Anita Gardner
Principal Planning Officer,
Directorate of Place

Dear Mr Rogers,

I have received the following comments from the environmental health officer.

## Proposed Ground Floor Plan

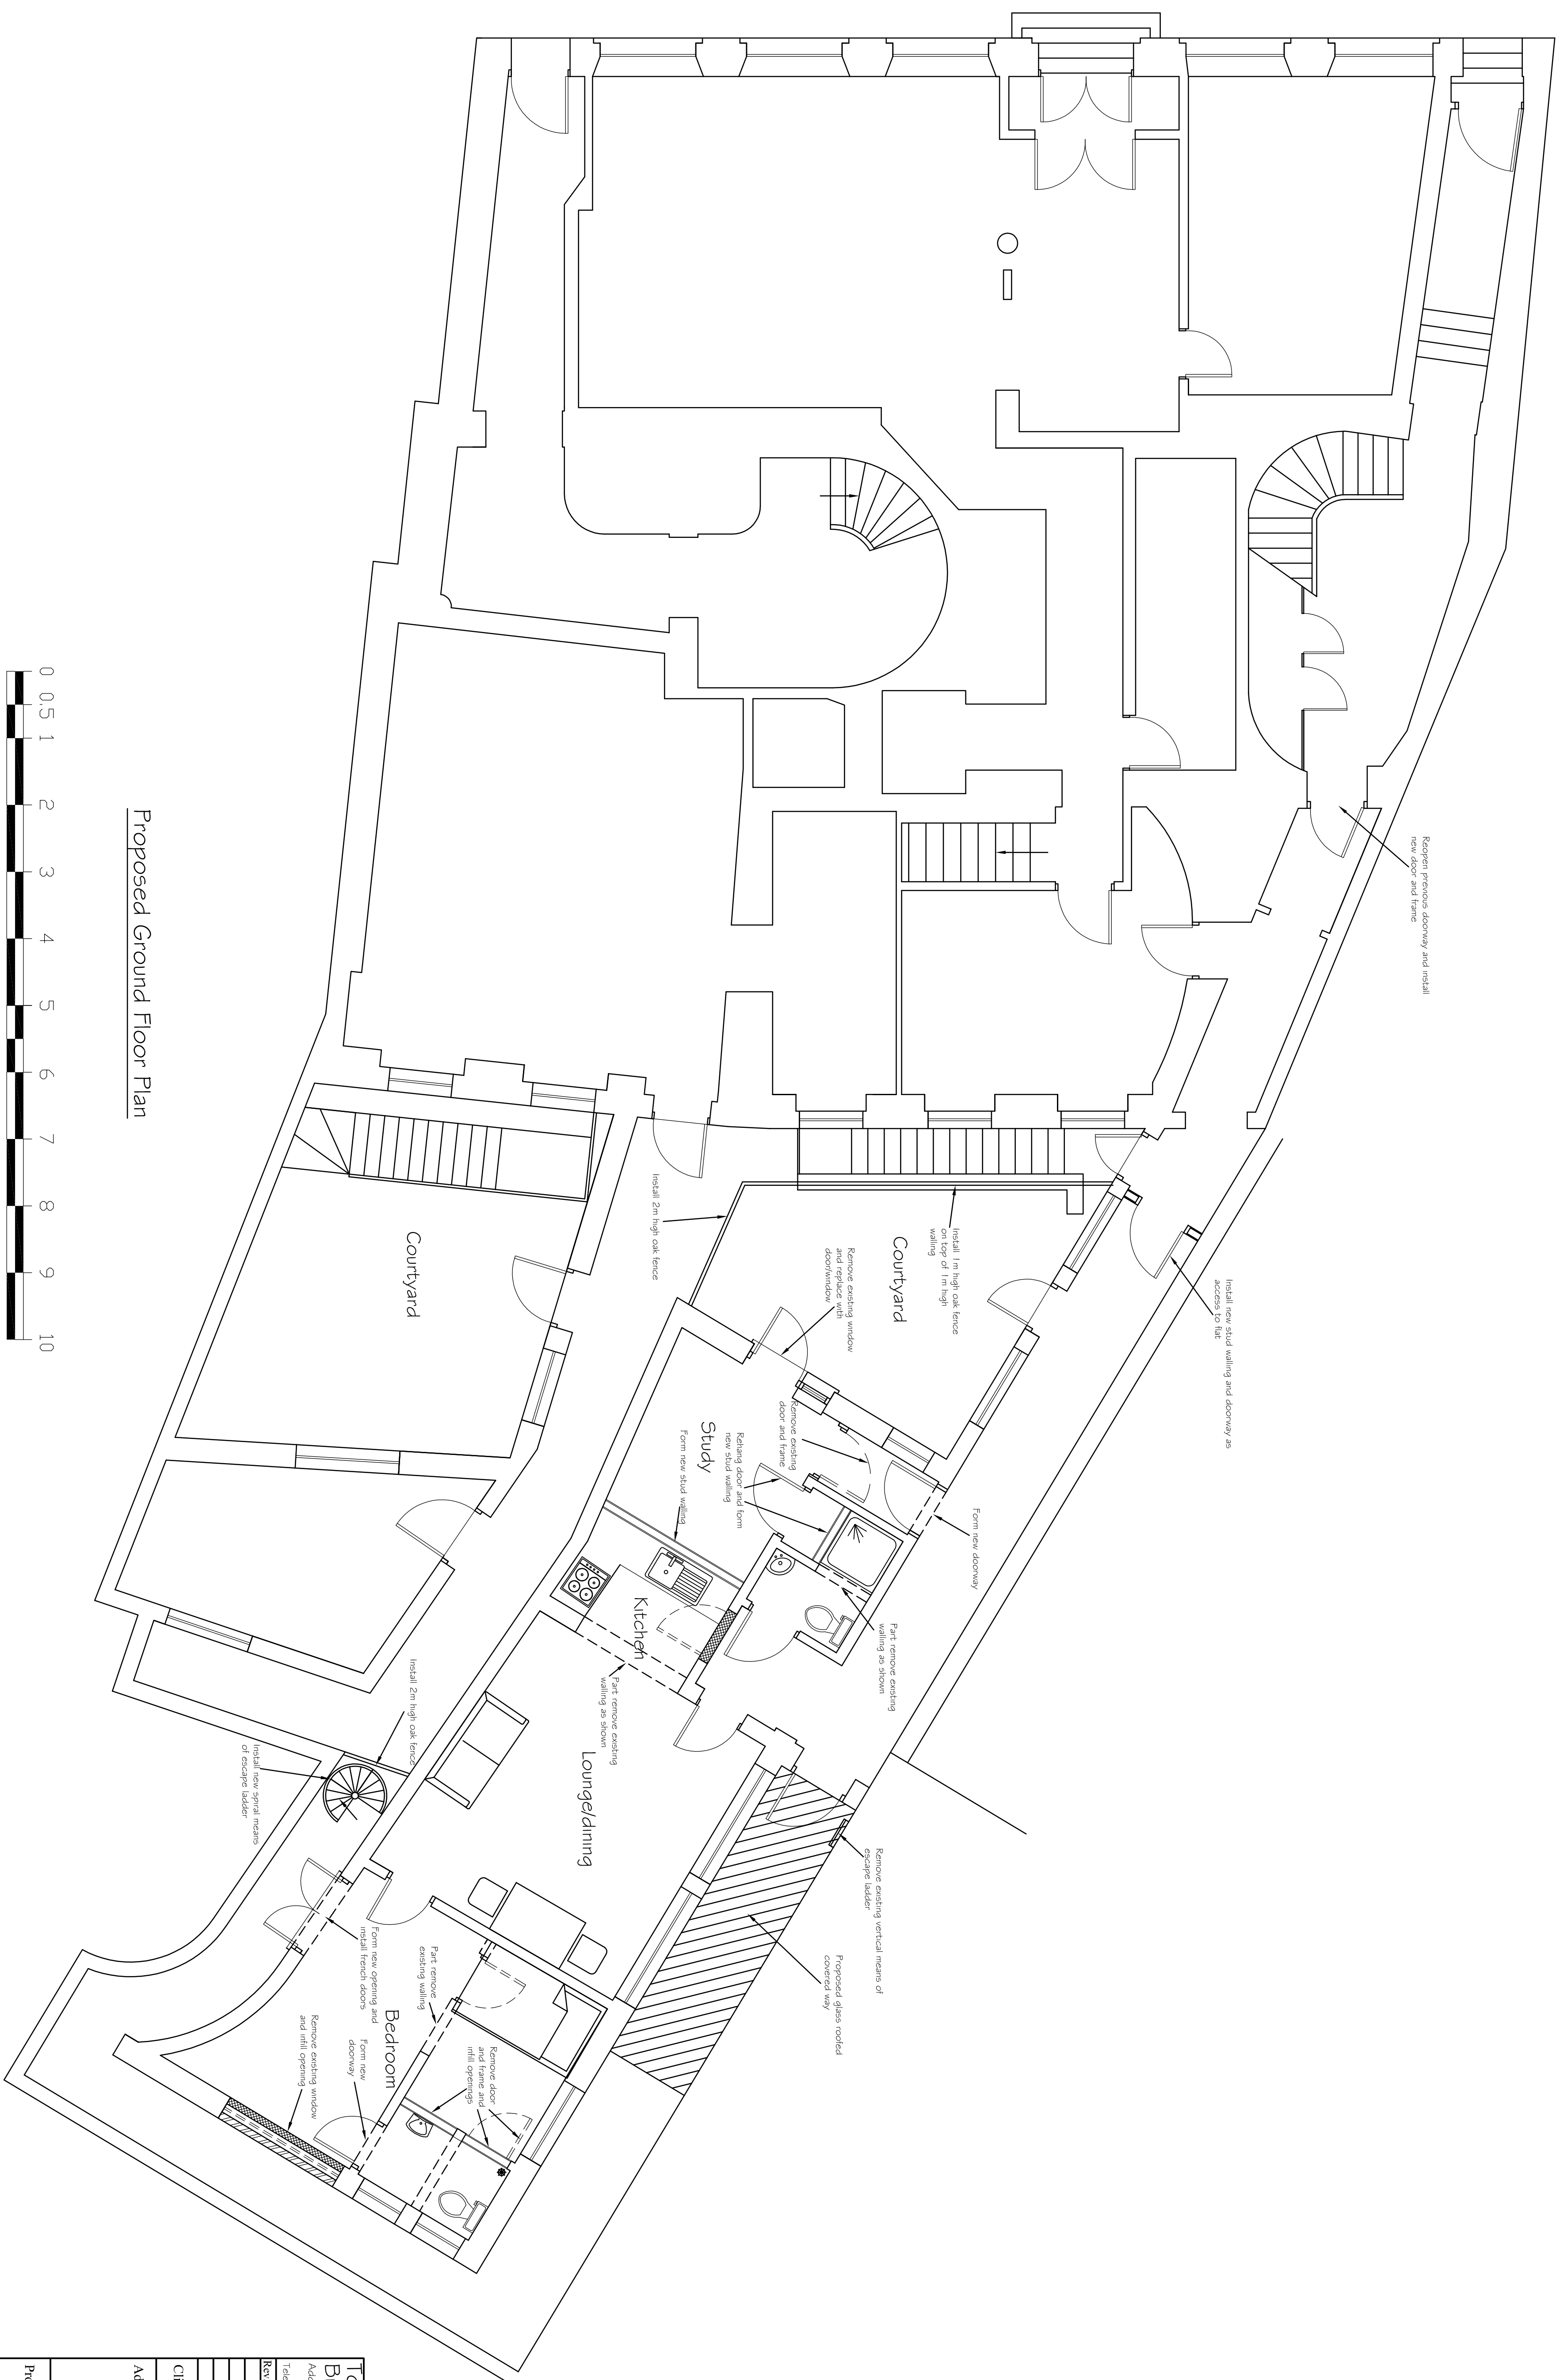
'One of the photographs shows an air conditioning unit in very close proximity and pointing directly towards the windows of the planned dwelling. This has the potential to negatively affect the residential amenity of any future occupiers by causing noise and vibration issues. However, the plans indicate that it is proposed to put a glass roof over this

area. I would therefore need to know what this air conditioning unit serves and if it is to be left in place, totally removed, replaced or moved somewhere else and if so where to before I would be confident that there will not be a noise issue. I would ask that the applicant provides answers to the above issues so that I can make a full assessment. Without this information I would have to consider objecting to the application on noise grounds or requesting a noise assessment and potentially sound insulation works in order to ensure that any future occupiers are not disturbed by noise from the unit.'

Just to let you know it has been removed.
